File No: R/2016/1/A
Our Ref: 2016/630380

MP 08_0098 – Alterations and Additions to The Star Casino Complex and New Hotel on former Switching Station – MOD 14

The City of Sydney (the City) has had the opportunity to review the Applicant's Environmental Assessment for proposed MOD 14 to Part 3A approval MP 08_0098.

1 DEMOLITION PLAN - LEVEL 00
A3000/ 1:100

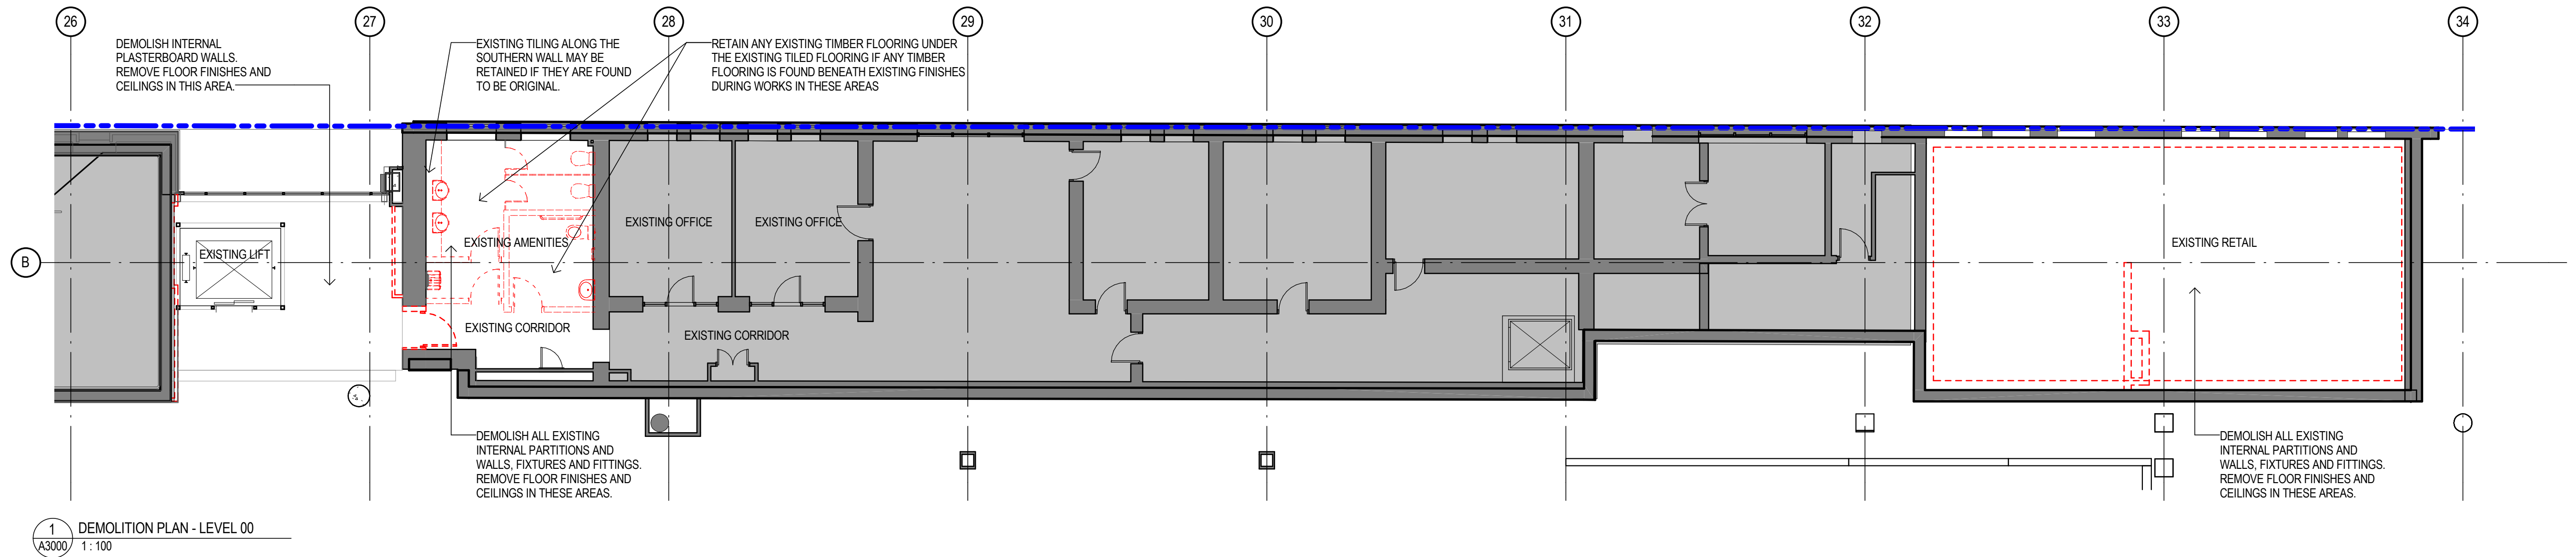
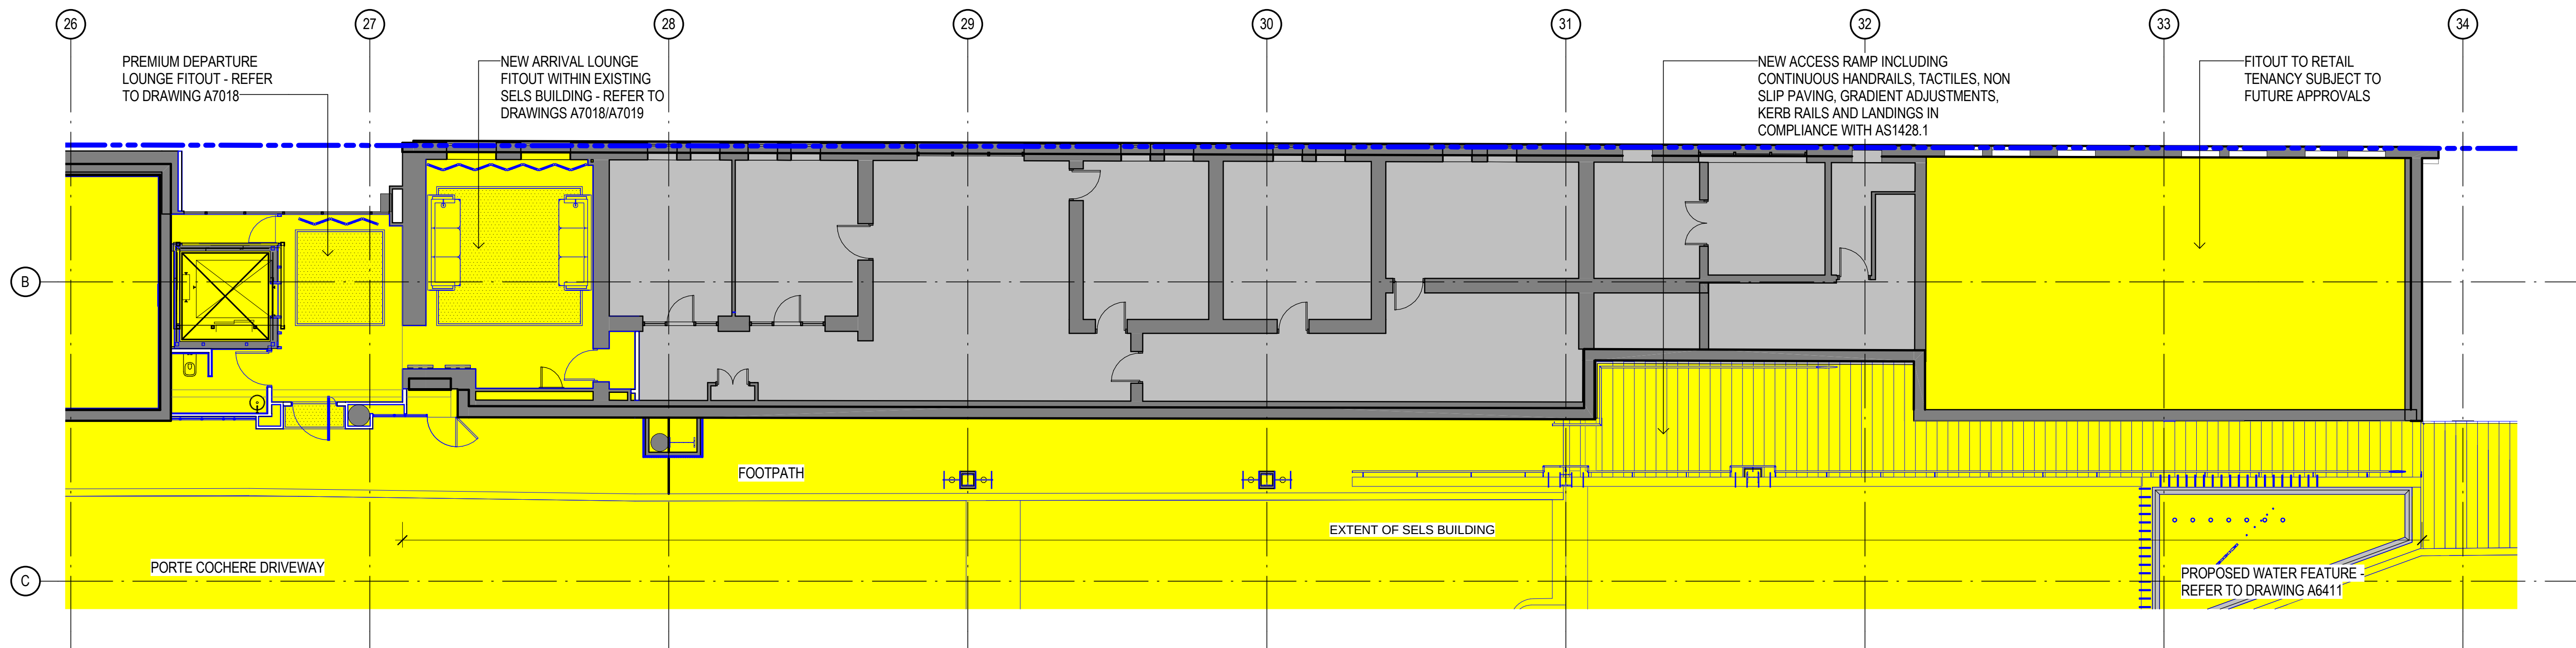
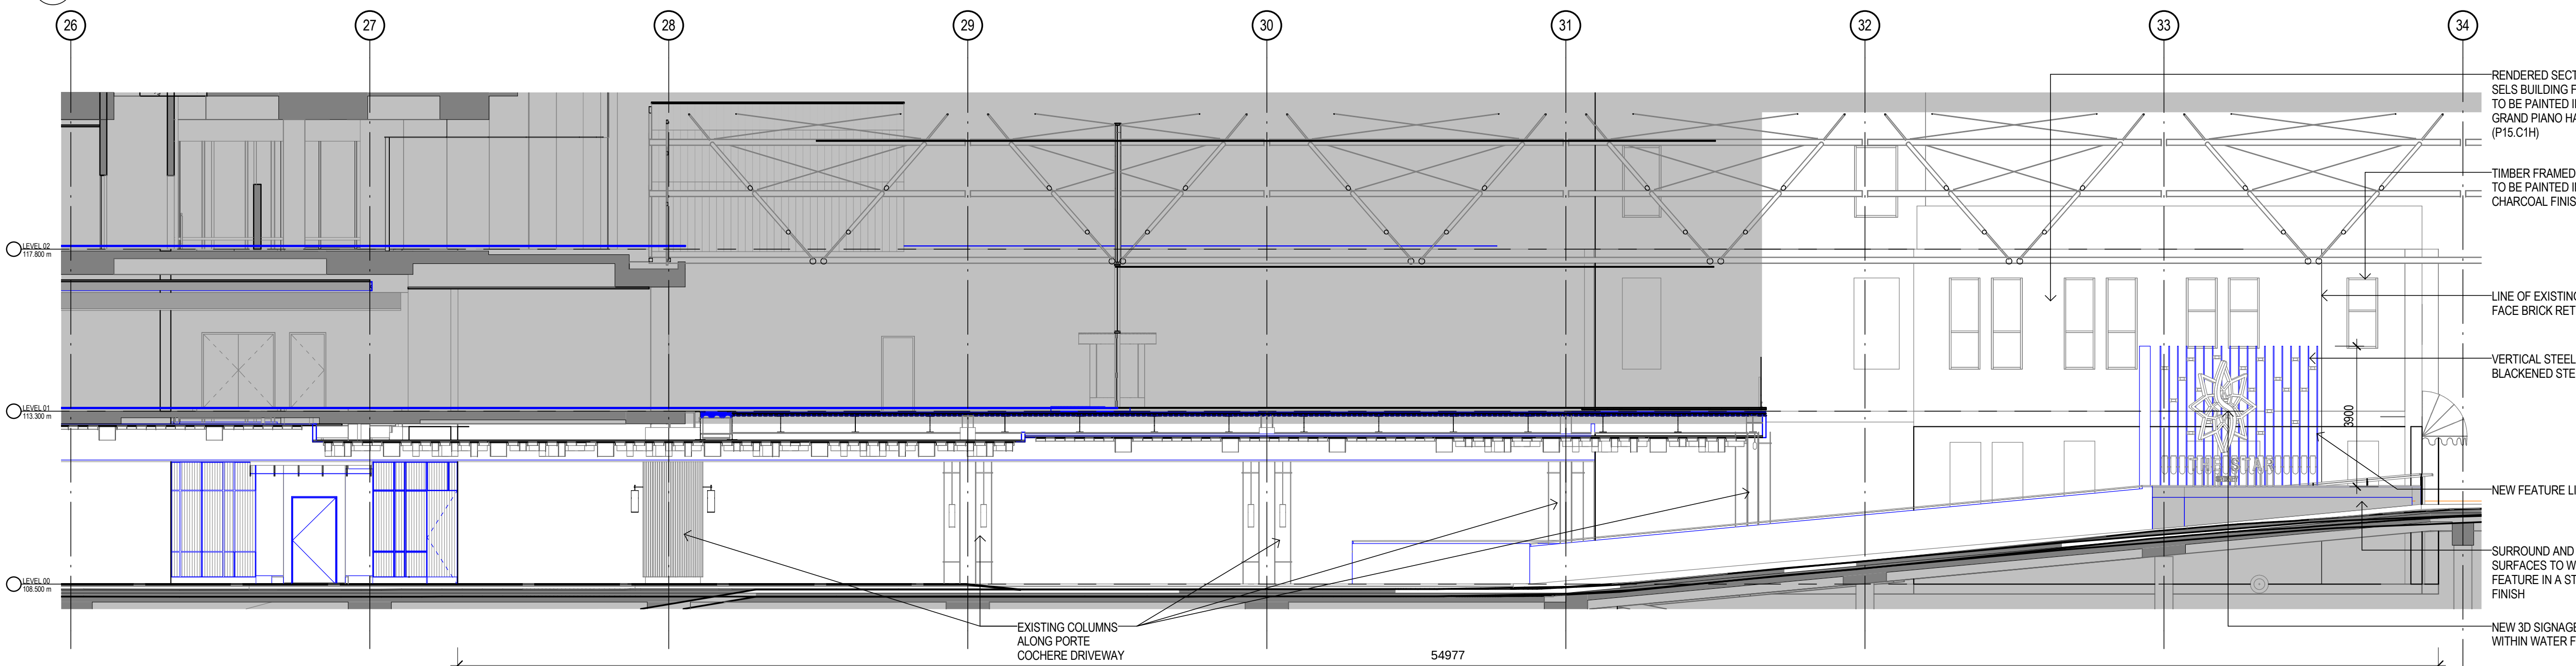
With regard to the arrival lounge, the demolition plan is unreadable and the proposed changes are difficult to decipher. Clear details of the demolition and the changes being proposed should be shown on the drawings, including sections, which should include the extent of demolition, lightweight construction of the new partition for the butler’s pantry and other changes to the room layout, removal of the suspended ceiling, details of screening, etc.

2 FLOOR PLAN-NORTHERN PORTE COCHERE CANOPY
1:250

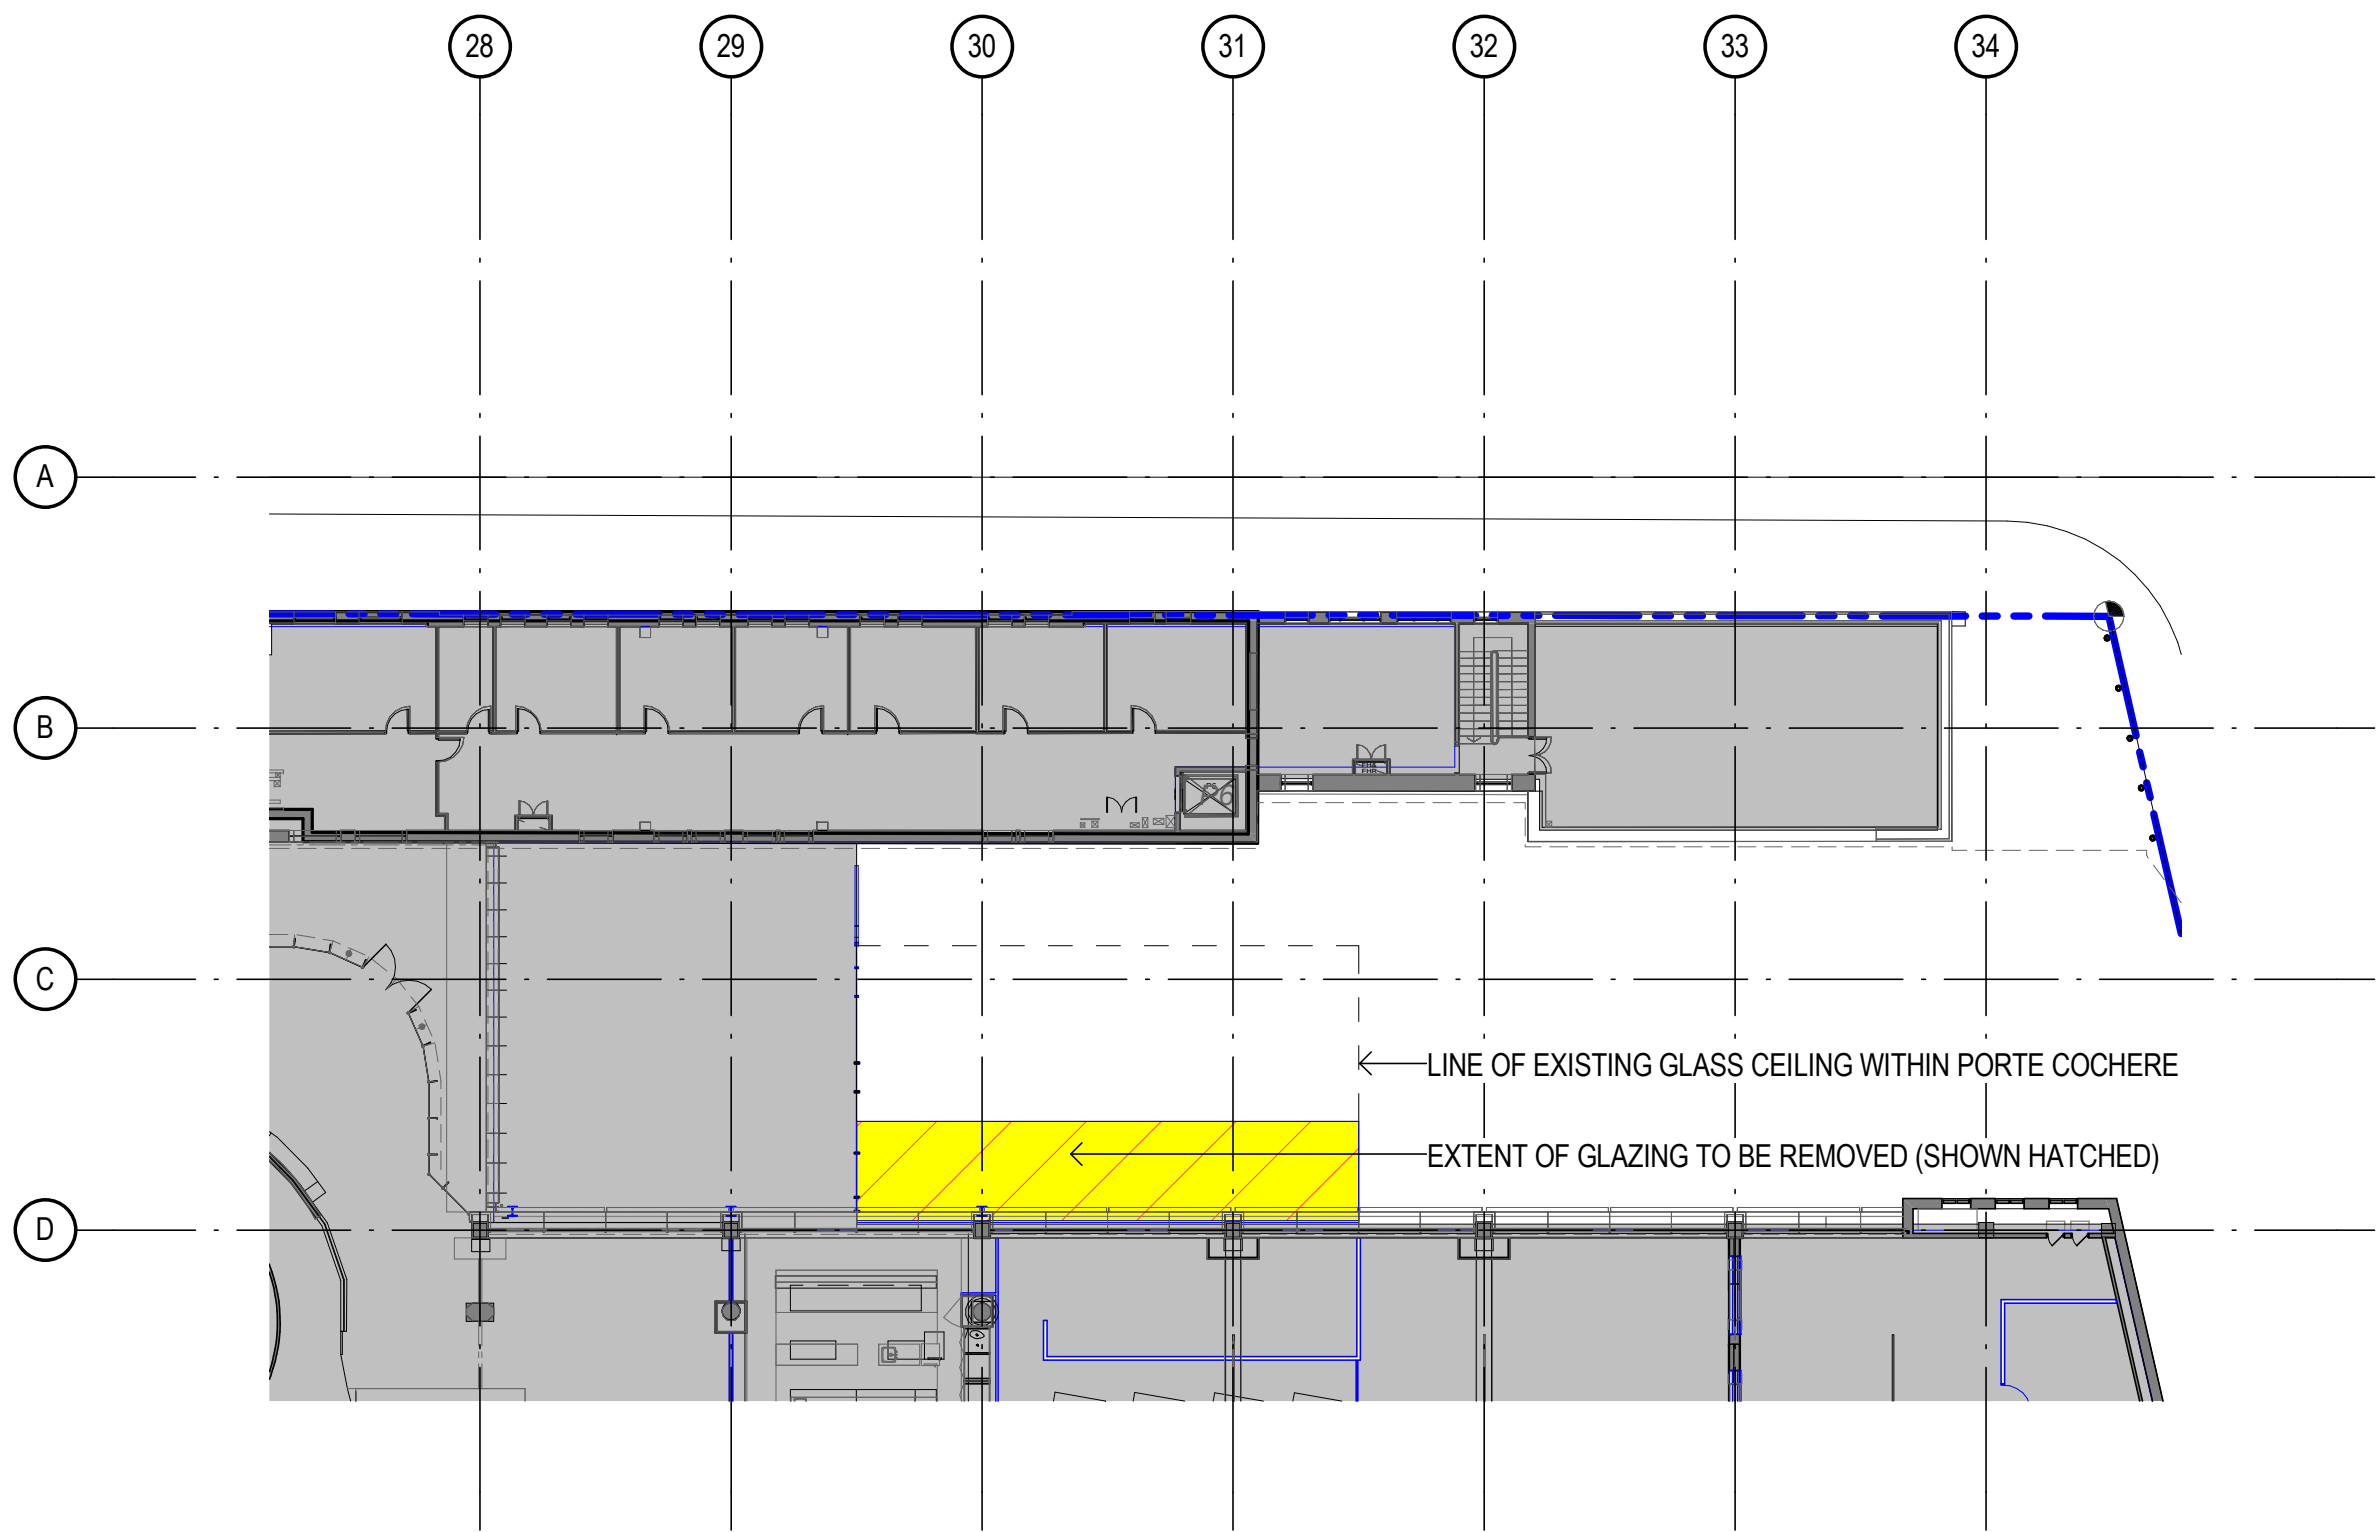
In relation to the new ceilings in the northern porte cochere near the SELS Building, there should be sections showing details of what is proposed.

Scale	Date Printed	
As indicated @ A1	27/02/17 4:45:05 PM	
Project Number	Drawing Number	Issue
303448	ASL-A6411	3

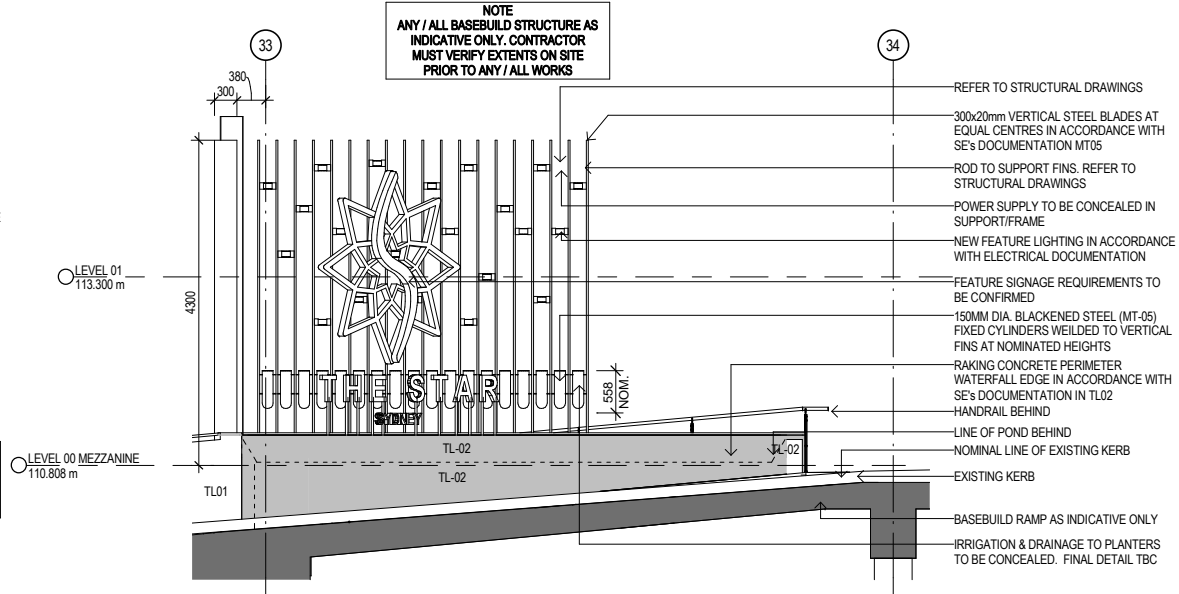
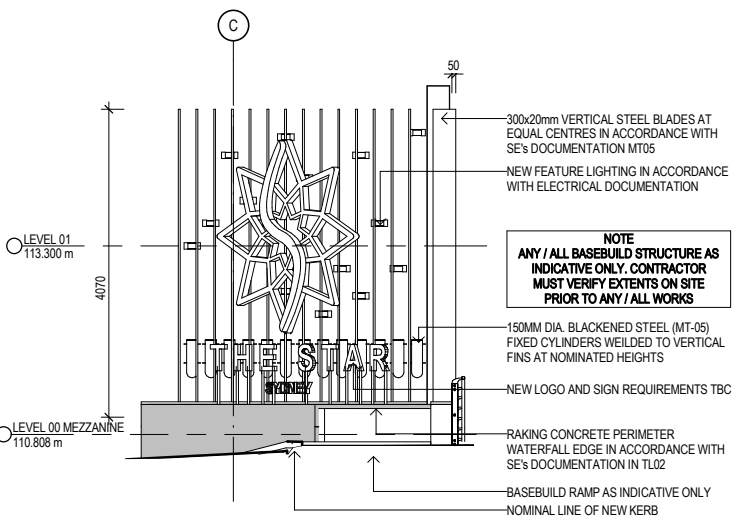
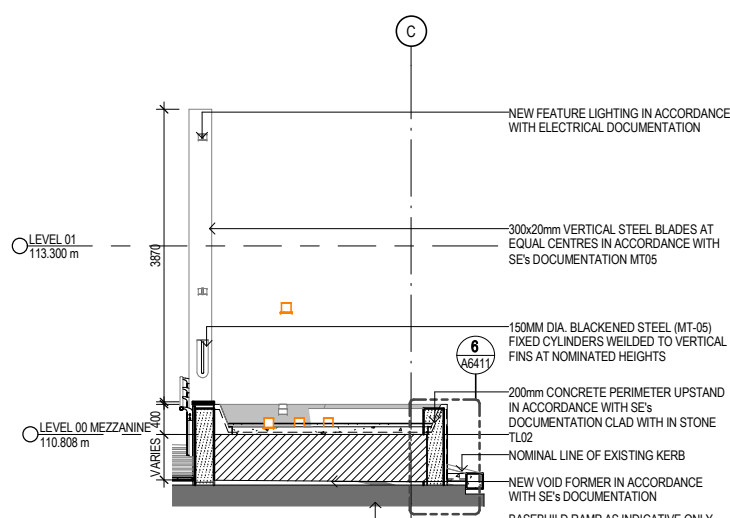
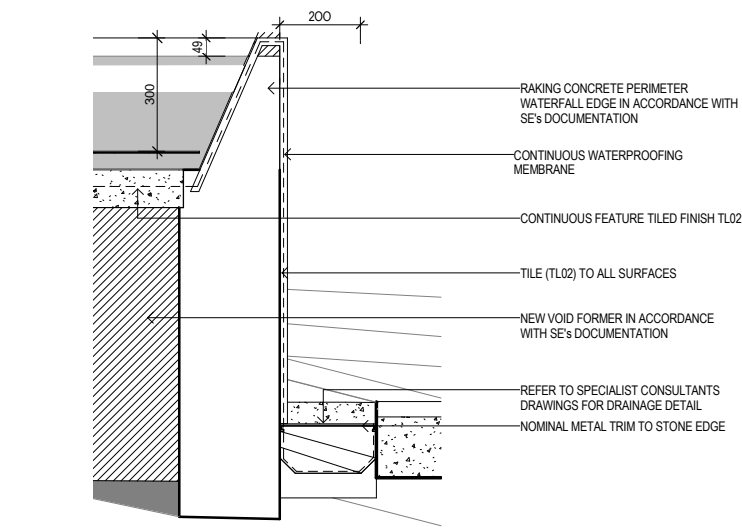
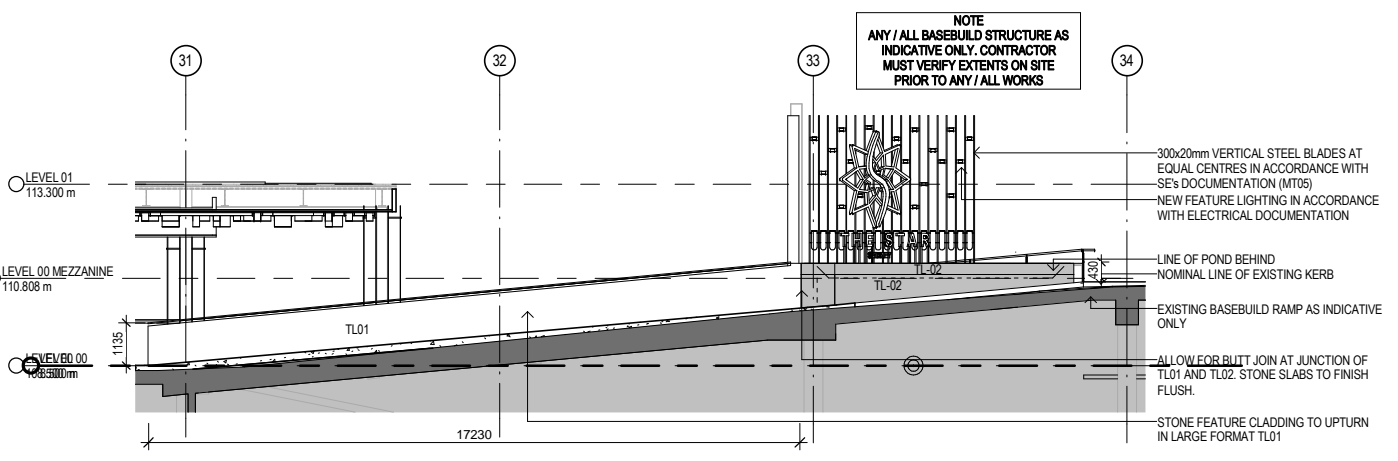
In relation to the proposed water feature and sculpture on the porte cochere side of the SELS Building, no details have been submitted on the drawings for this feature. In pre-DA advice given by the City to The Star, the City recommended that *to reduce its visual impact on the SELS Building the water feature structure should be no forward of the line of the face brick return of the SELS Building, and be reduced in height such that the top of it is no higher than the base of the sill of the first floor double-hung sash window within this brick return section of the building.*
